Appeal Decision

Appeal Ref: APP/R5510/D/22/3313468

291 Long Drive, Hillingdon, Ruislip HA4 0HT

- The appeal is made under section 78 of the Town and Country Planning Act 1990 against a refusal to grant approval required under Article 3(1) and Schedule 2, Part 1, Class A of the Town and Country Planning (General Permitted Development) (England) Order 2015 (as amended).
- The appeal is made by Mr Naveed Entezam against the decision of the Council of the London Borough of Hillingdon.
- The application Ref 69941/APP/2022/2690, dated 30 August 2022, was refused by notice dated 7 October 2022.
- The development proposed is demolition of existing utility building and 4m single storey rear extension.

Drawing Title
Existing ground floor

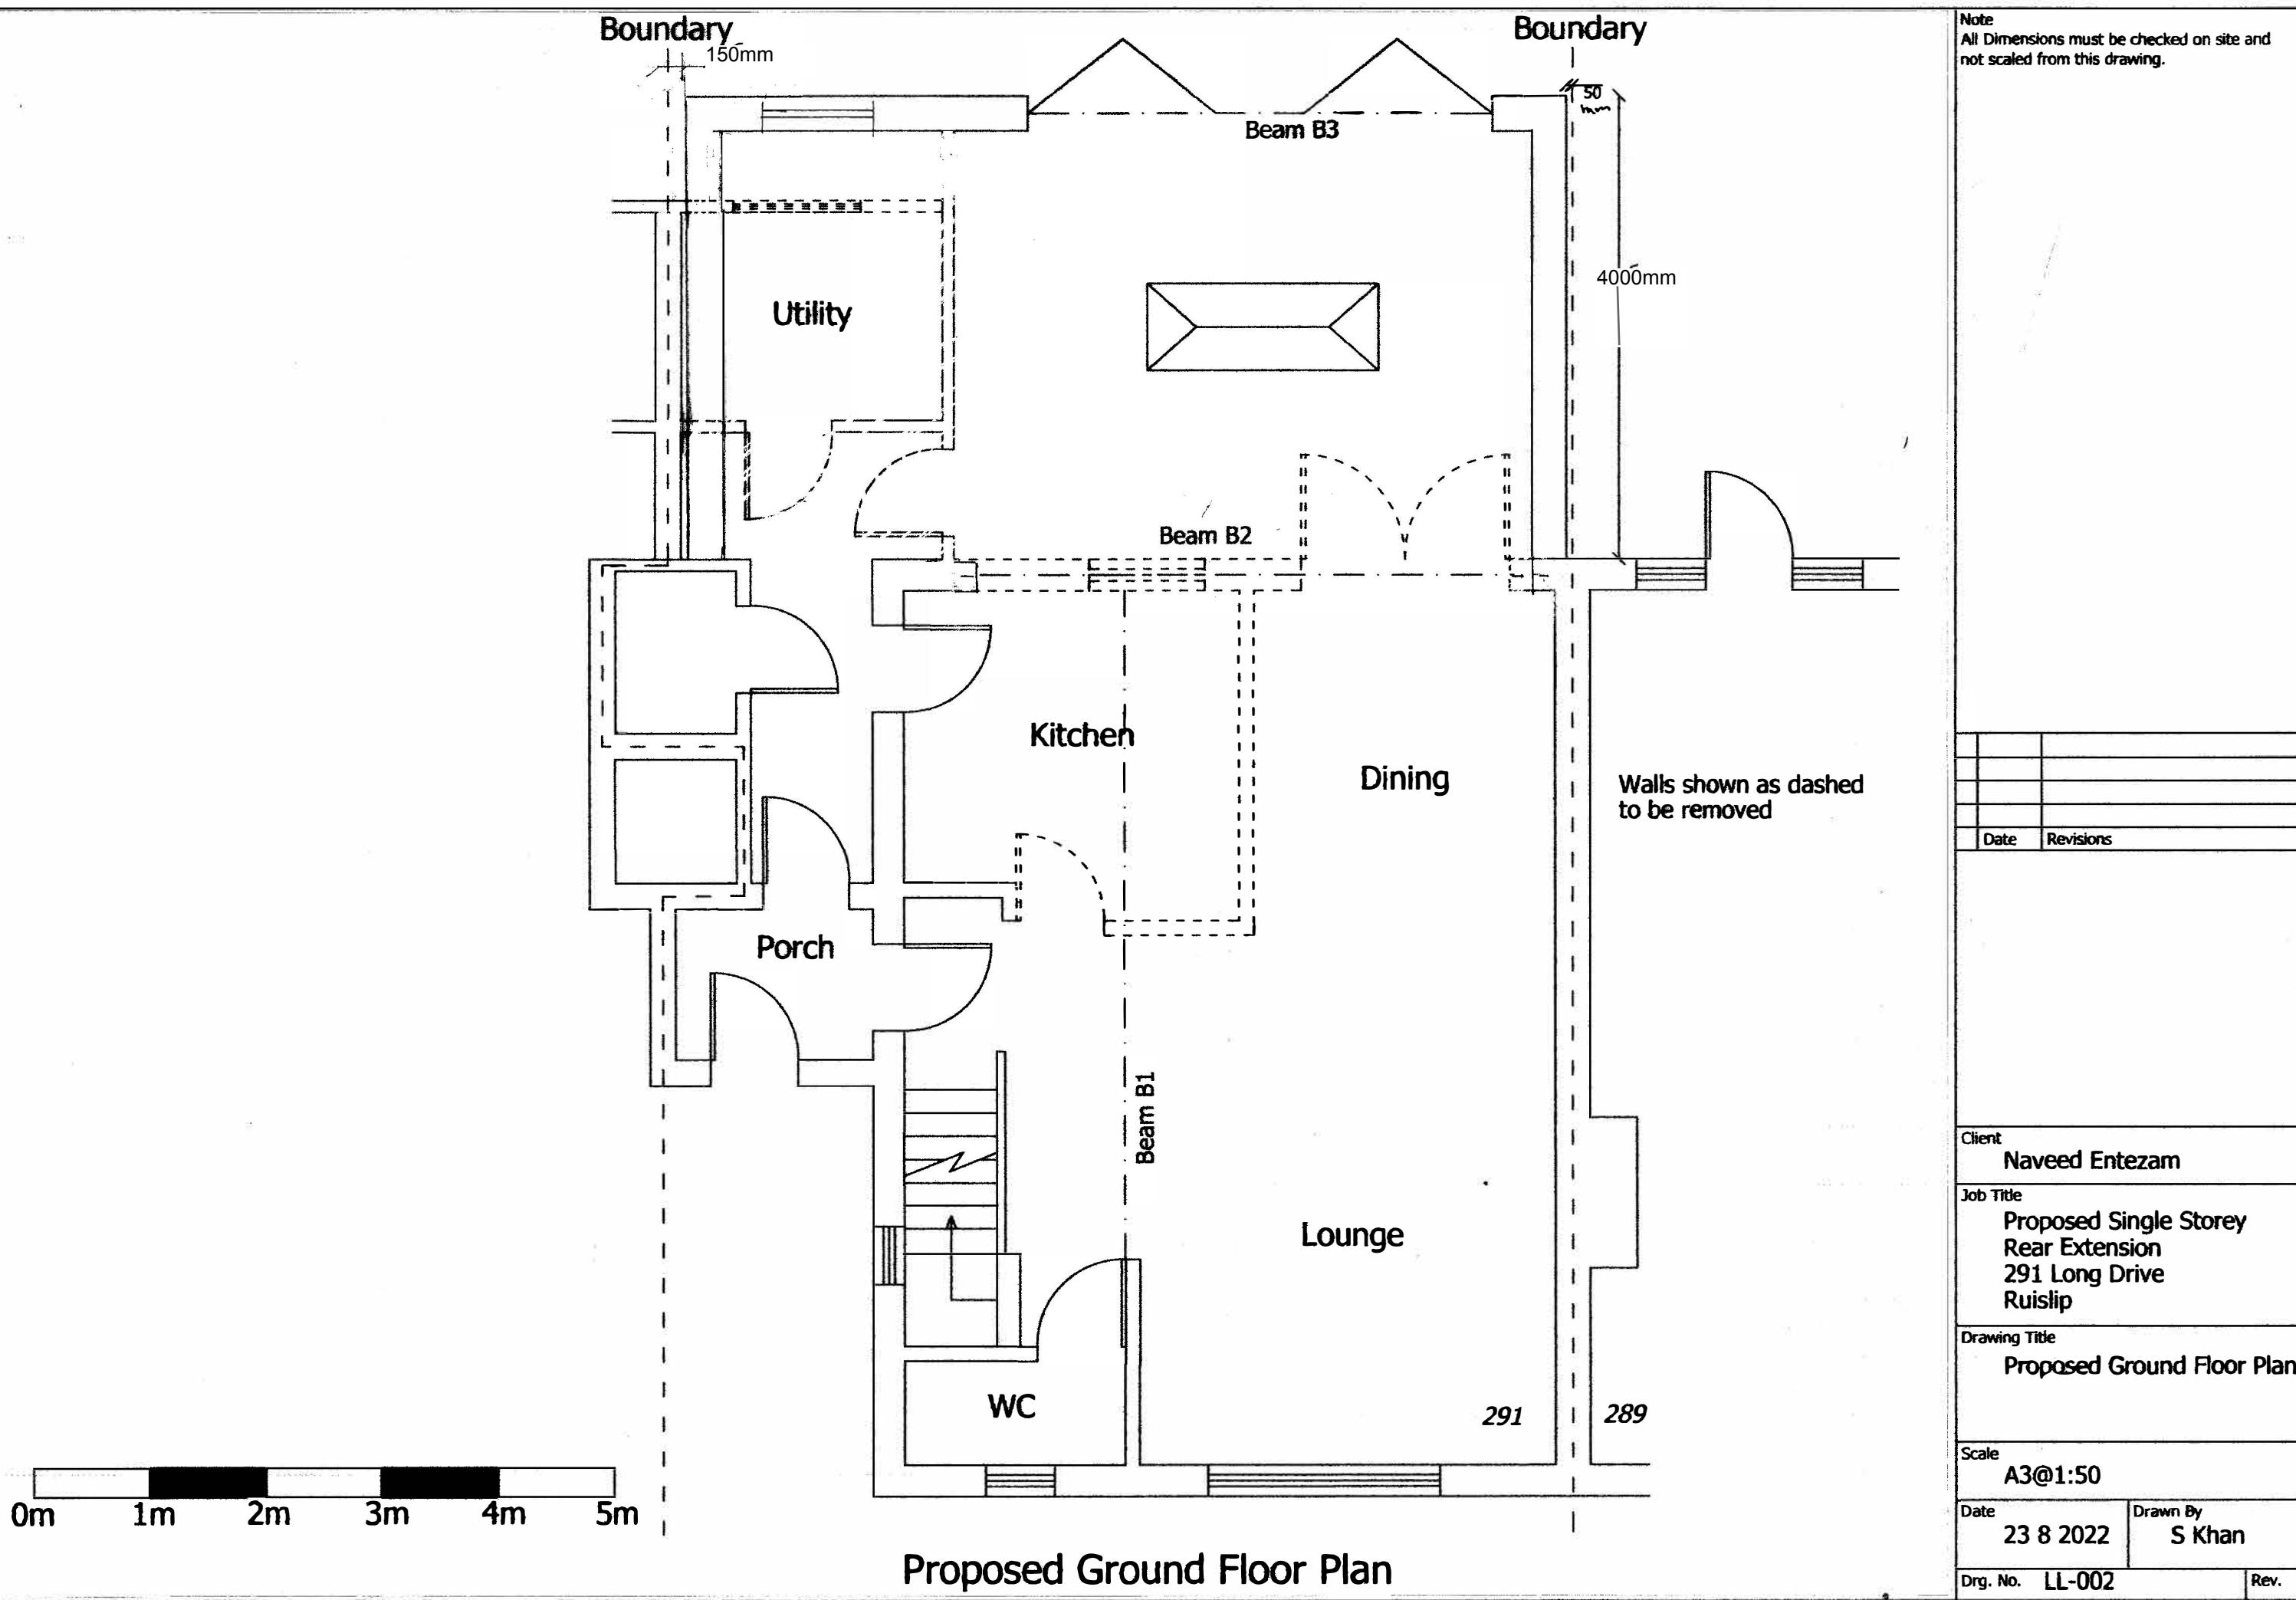
9. The proposal would involve the erection of a single storey rear extension which would project 4 metres from the rear elevation with an eaves height of 3 metres and a maximum height of 3.1 metres. It would span the full width of the appeal property. The plans indicate that all the existing rear projection except the existing party wall with No. 293 would be demolished. The Council suggests that this rear projection is part of the original dwelling, which has not been disputed by the appellant. Following my observations on site and with no substantive evidence to contrary, I consider it to be part of the original dwelling.

10. The Government's Technical Guidance¹ indicates that a wall forming a side elevation will be any wall that cannot be identified as being a front wall or a rear wall. The staggered rear elevation of the property means that there is an inner side wall to the existing rear projection.

11. Even though most of this projection would be demolished, the proposed extension would extend beyond its original inner side wall. The limitations at paragraph A.1(j) of Class A are based on the original dwelling. Consequently, these limitations apply even if part of the original dwelling is removed.

Drawing Title
Proposed elevations

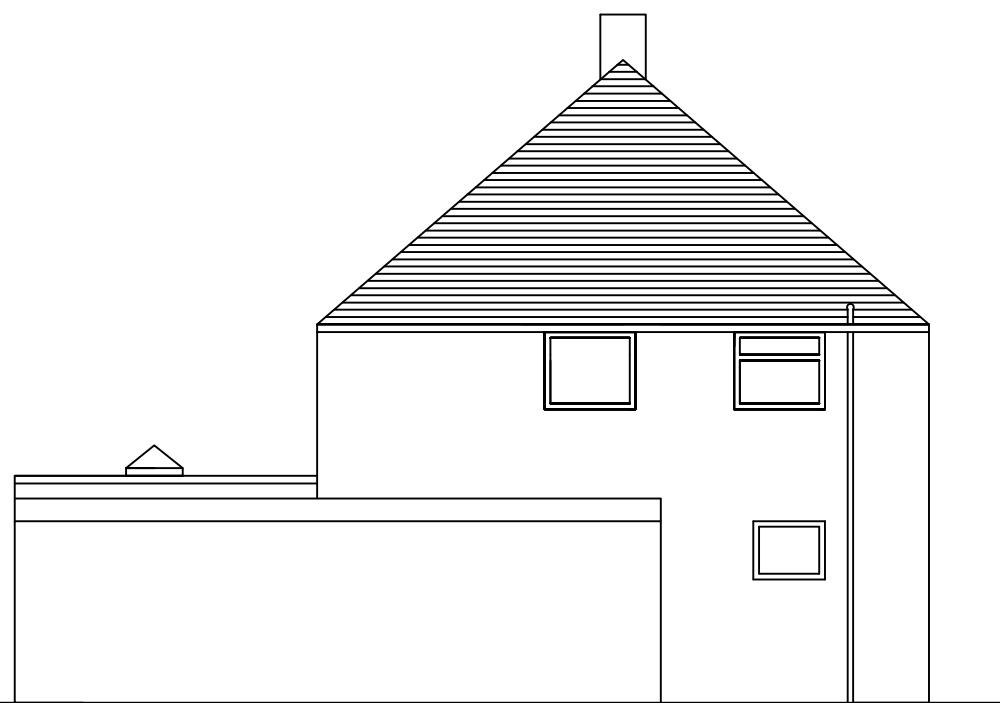
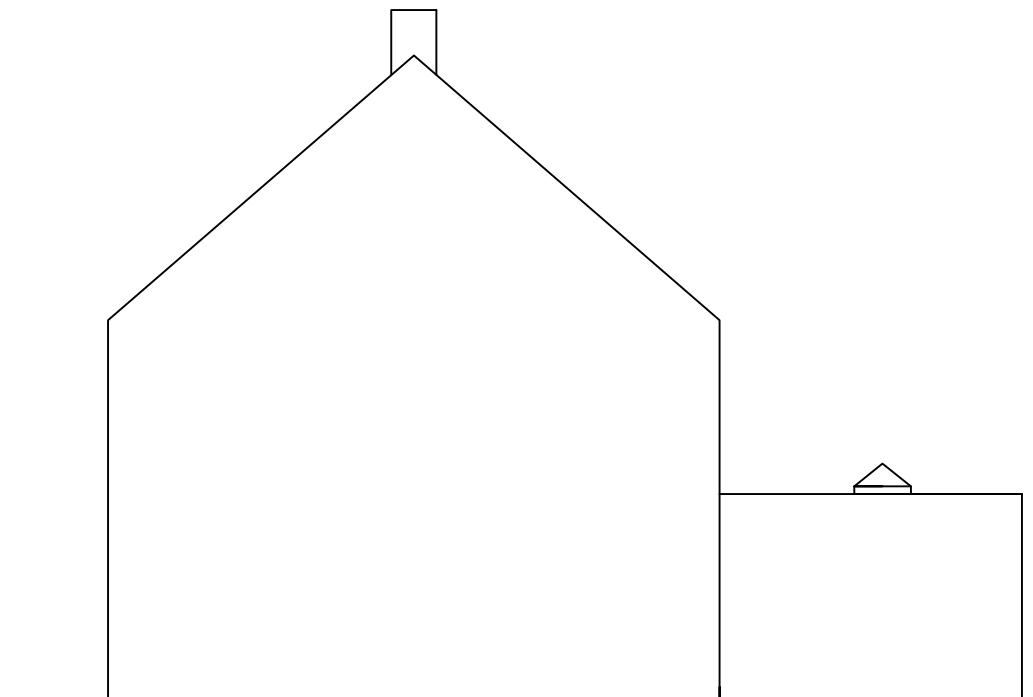
12. Whilst the proposal would not extend beyond the rear wall of the dwelling by more than 6 metres nor exceed 4 metres in height, it would extend beyond a wall forming a side elevation of the original dwelling and it would have a width greater than half the width of the original dwelling.

13. Accordingly, for the above reasons, I conclude that the proposed development would not comply with paragraph A.1(j)(iii) and would not therefore constitute permitted development under Schedule 2, Part 1, Class A of the GPDO.
